WEST SUSSEX COUNTY COUNCIL CONSULTATION

TO:	Arun District Council FAO: Simon Davis
FROM:	WSCC - Highways Authority
DATE:	21 November 2019
LOCATION:	Land east of Shripney Road & south of <u>Haddan House</u> , Shripney Road, Bersted, PO22 9NW
SUBJECT:	BE/109/19/OUT Outline application with some matters reserved for up to 46 No dwellings together with access. This application is a Departure from the Development Plan.
RECOMMENDATION:	More Information
S106 CONTRIBUTION TOTAL:	To follow

Fig. 6.2 - Extract from Transport Statement – Visibility Splays & Junction Arrangement

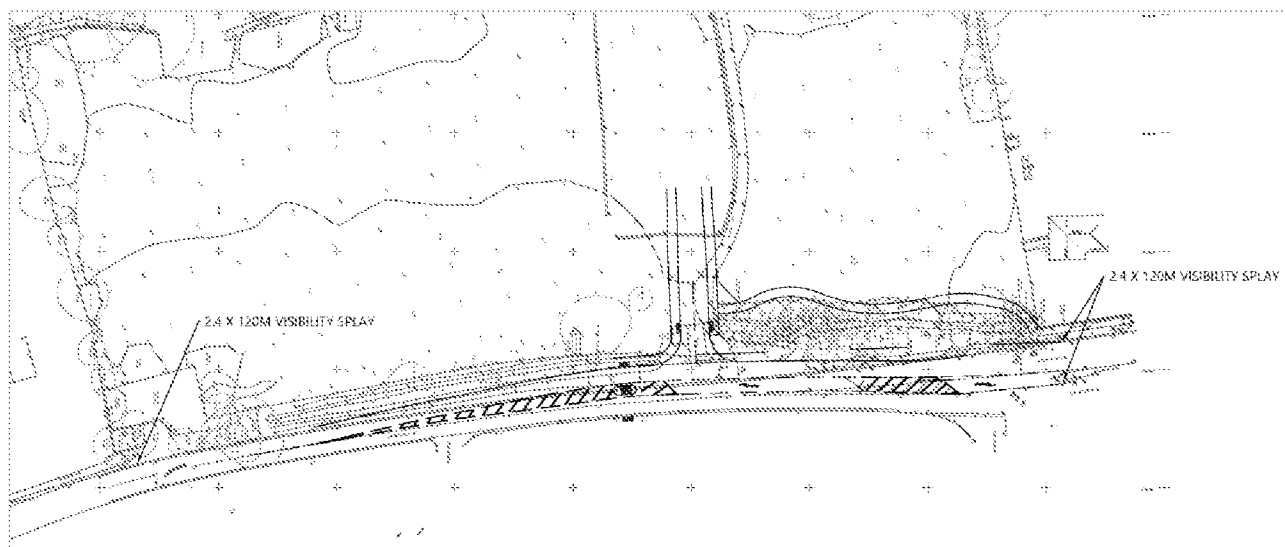
Nevertheless, the plans do not appear to show full extent of splays, which are not clear. These should be taken to nearside carriageway edge and only pass through publicly maintained and applicant land. The applicant should provide a clearer plan showing that full extent of the required splays is achievable. The LHA also require that the raw ATC data is provided including location of speed counter and weather data to ensure no extreme conditions during the survey.

Figure 3.2 – Proposed site access arrangements

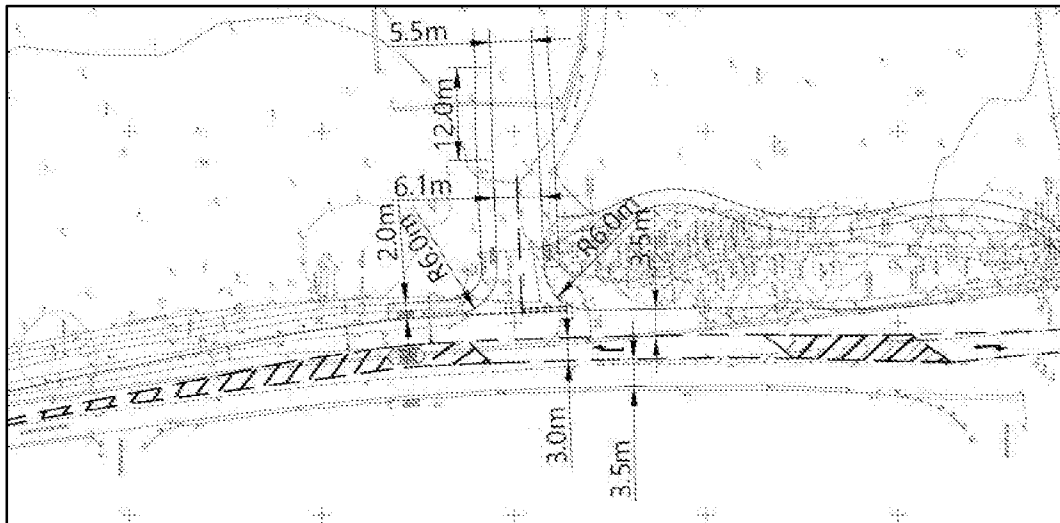
The site access is proposed with 6m kerb radii. Considering the posted speed limit, it is advisable for the radii to be increased to 9m. Whilst this will potentially result in higher entry speeds into the development, it will allow turning vehicles to clear the A29 more quickly.

Swept path tracking for refuse collection vehicle has been undertaken. As it is advised kerb radii be increased and the current plans available online are quite faint, the LHA advise that clearer swept path tracking plans are provided.
